ENG-CDR19002-R2-CDs.pdf Markup Summary

Subject: EPC ENG Review
Page Index: 1
Date: 2/24/2020 10:49:20 PM
Author: dsdrice
Color: ■
Layer:
Space:
Page Label: 1

LORSON RANCH
CREEKSIDE DEVELOPMENT
EAST FORK JIMMY CAMP CREEK
CHANNEL PLAN AND PROFILE STA 35+00 TO STA 45+00
EL PASO COUNTY, COLORADO

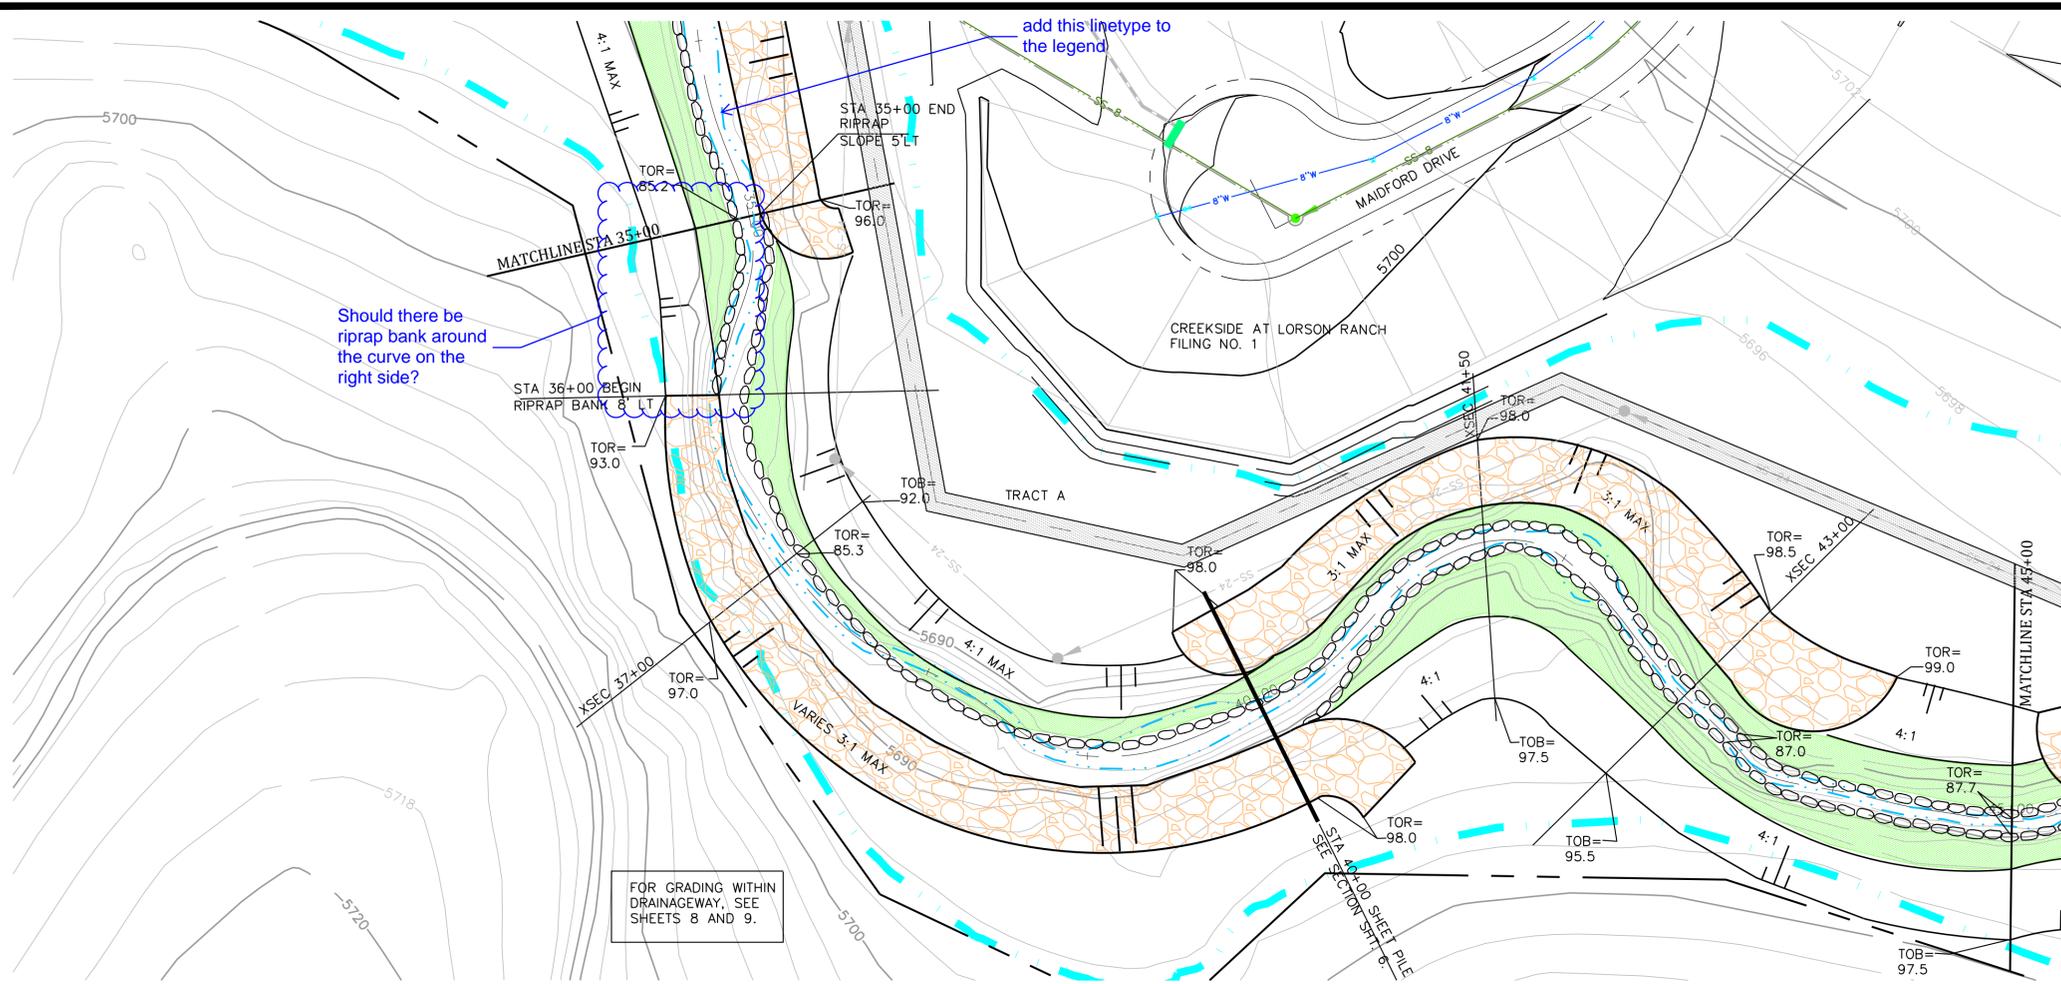
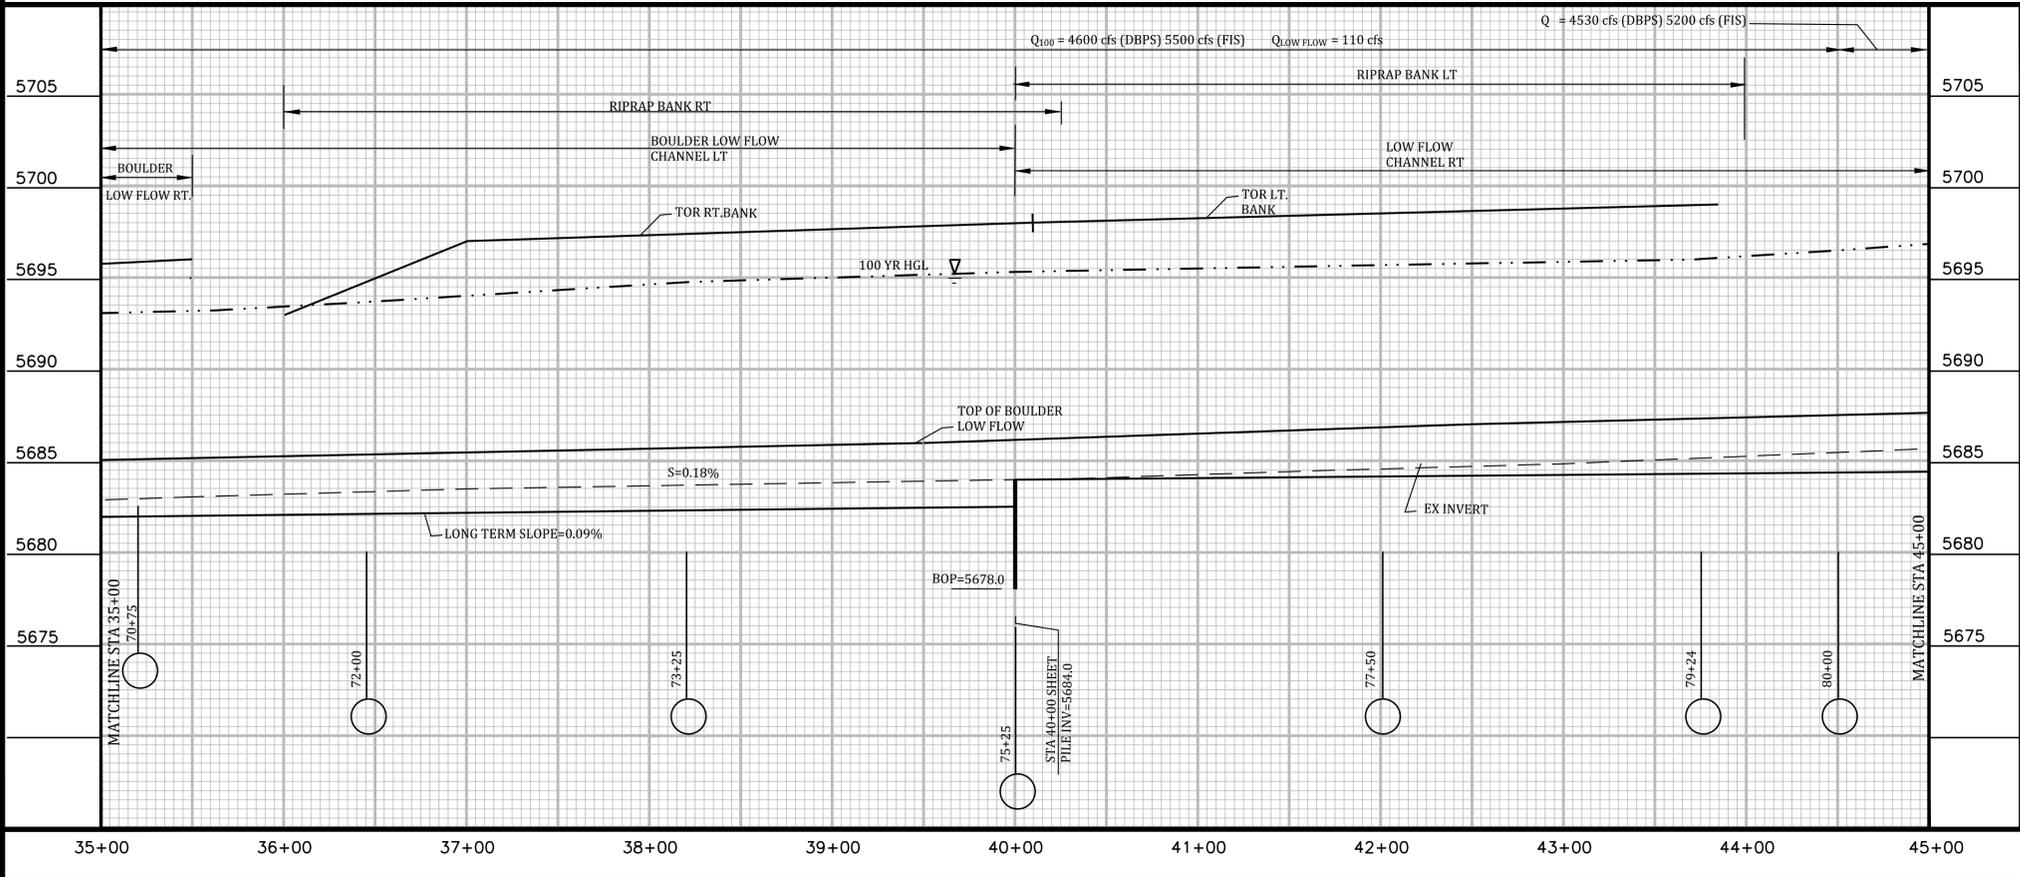
show boulder embedment depth

Show water line

dimension

LORSON RANCH
CREEKSIDE DEVELOPMENT
EAST FORK JIMMY CAMP CREEK
 CHANNEL PLAN AND PROFILE STA 45+00 TO 50+00
 EL PASO COUNTY, COLORADO

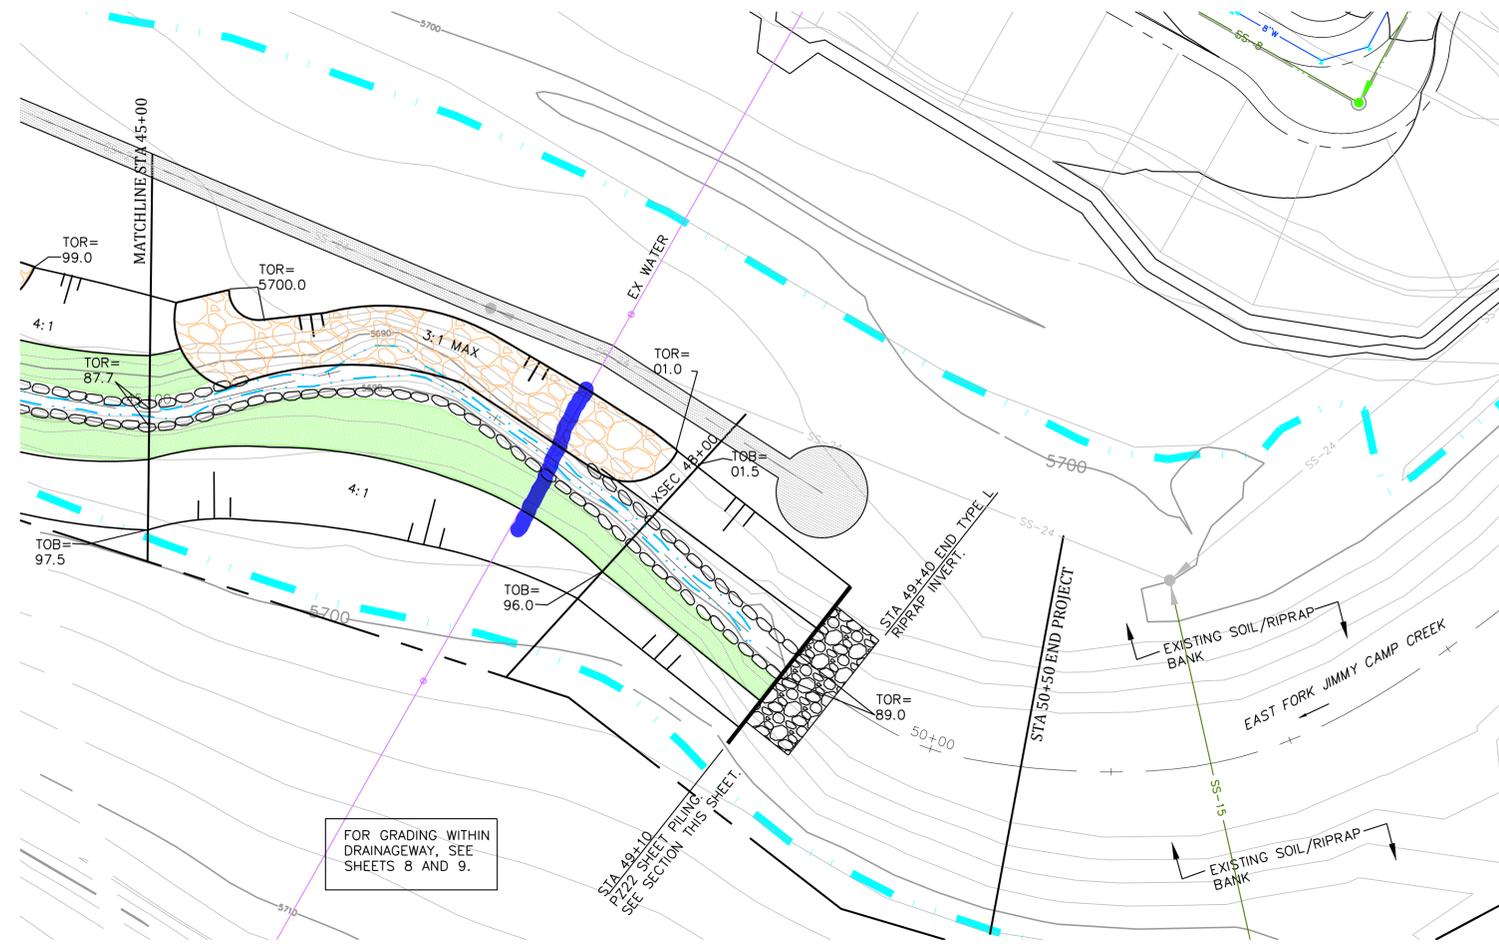
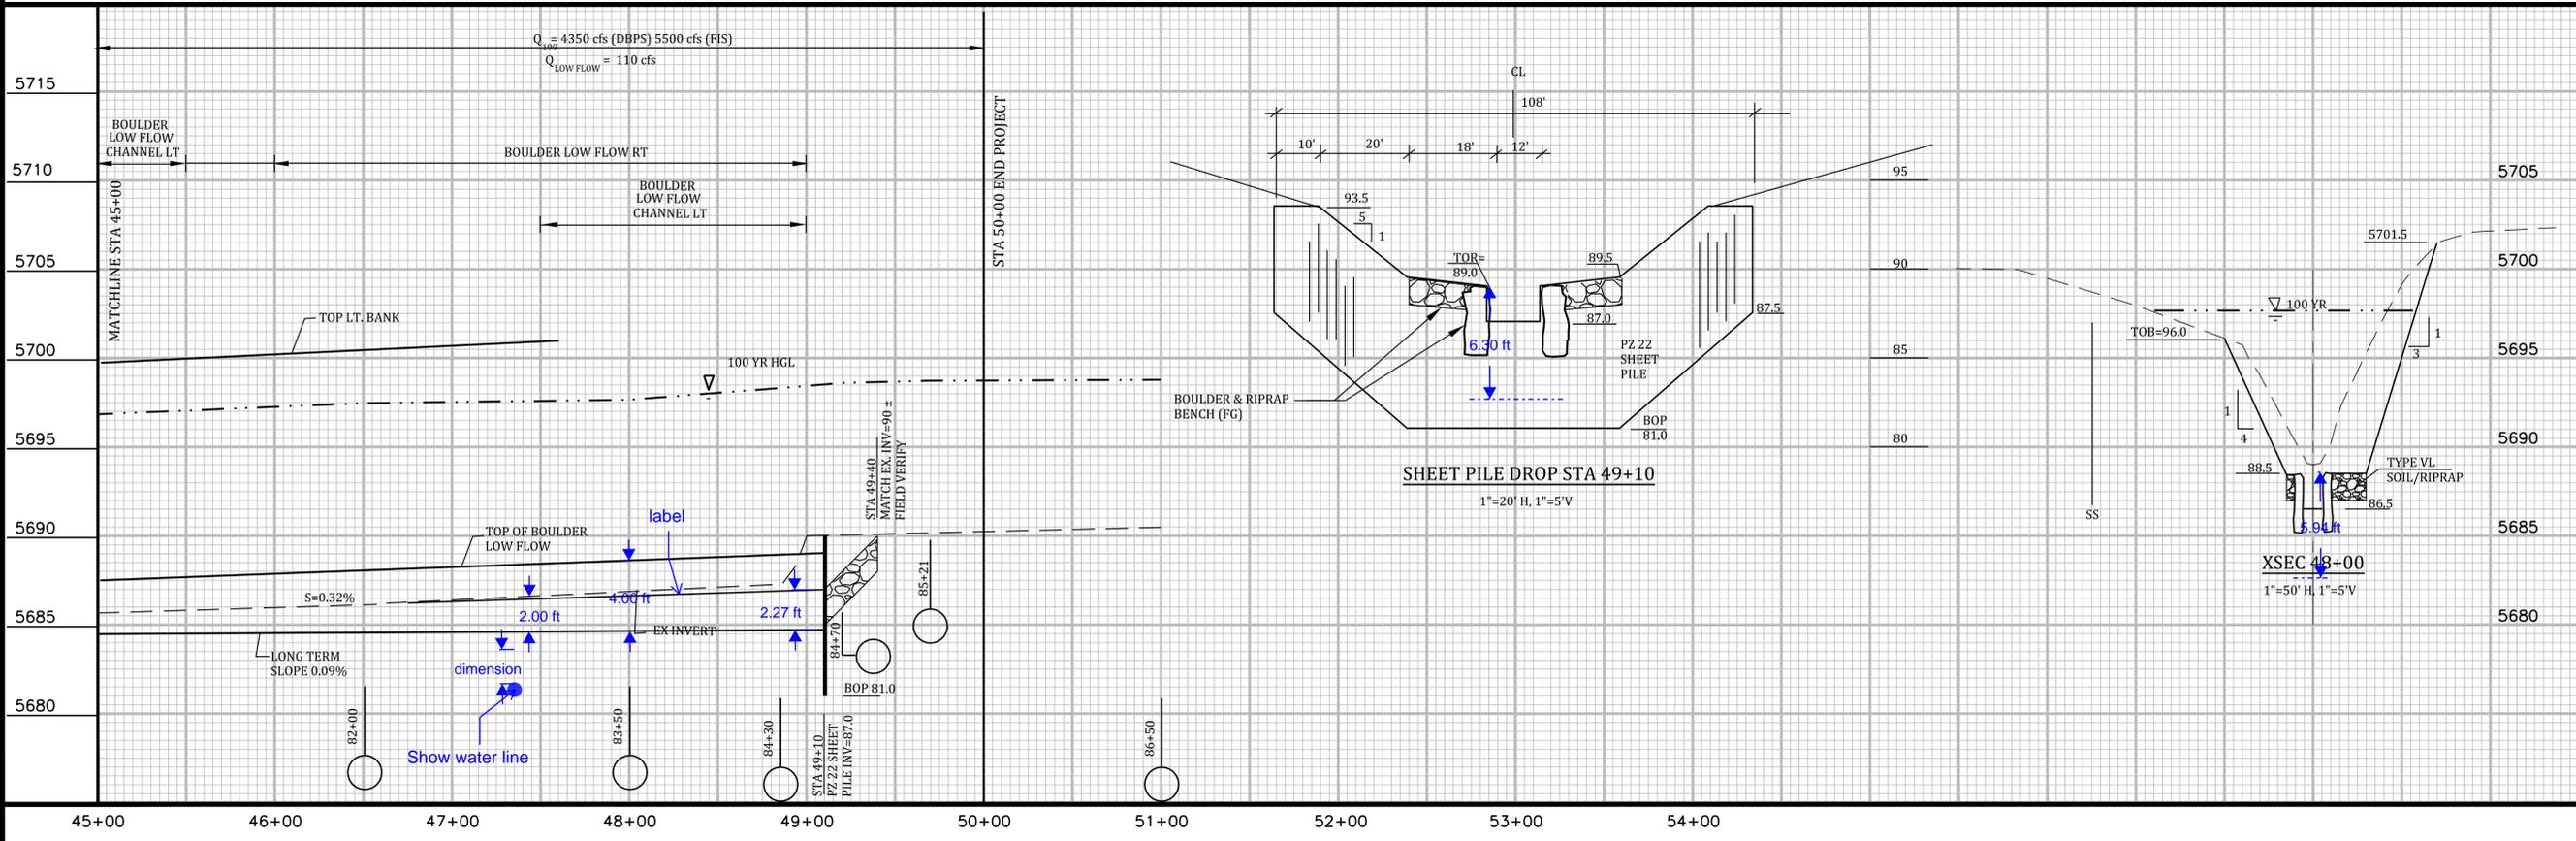
Verify/label potential conflicts with utilities

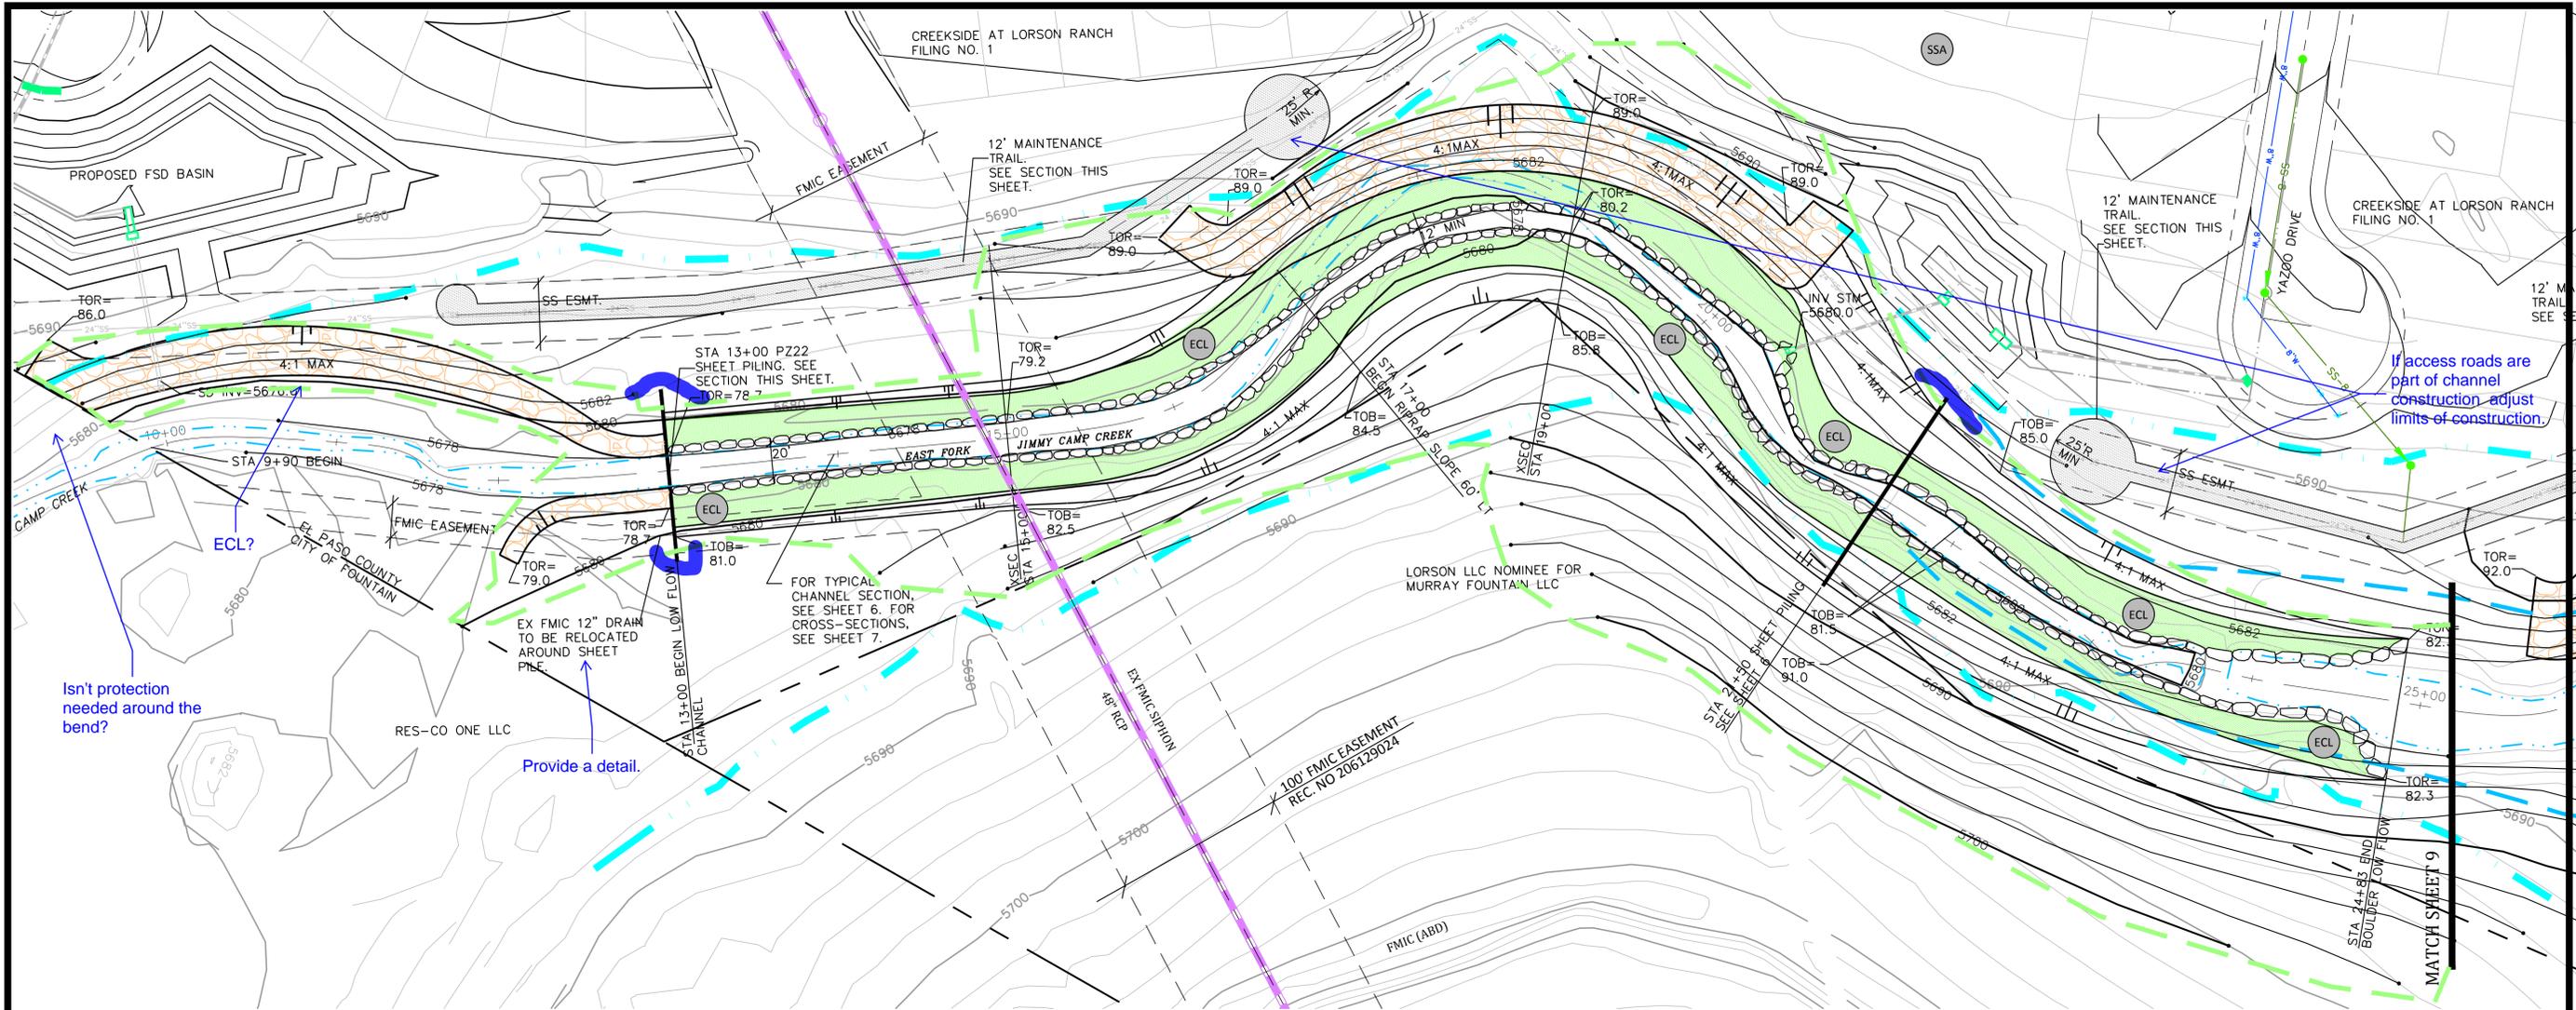
Isn't protection needed around the bend?
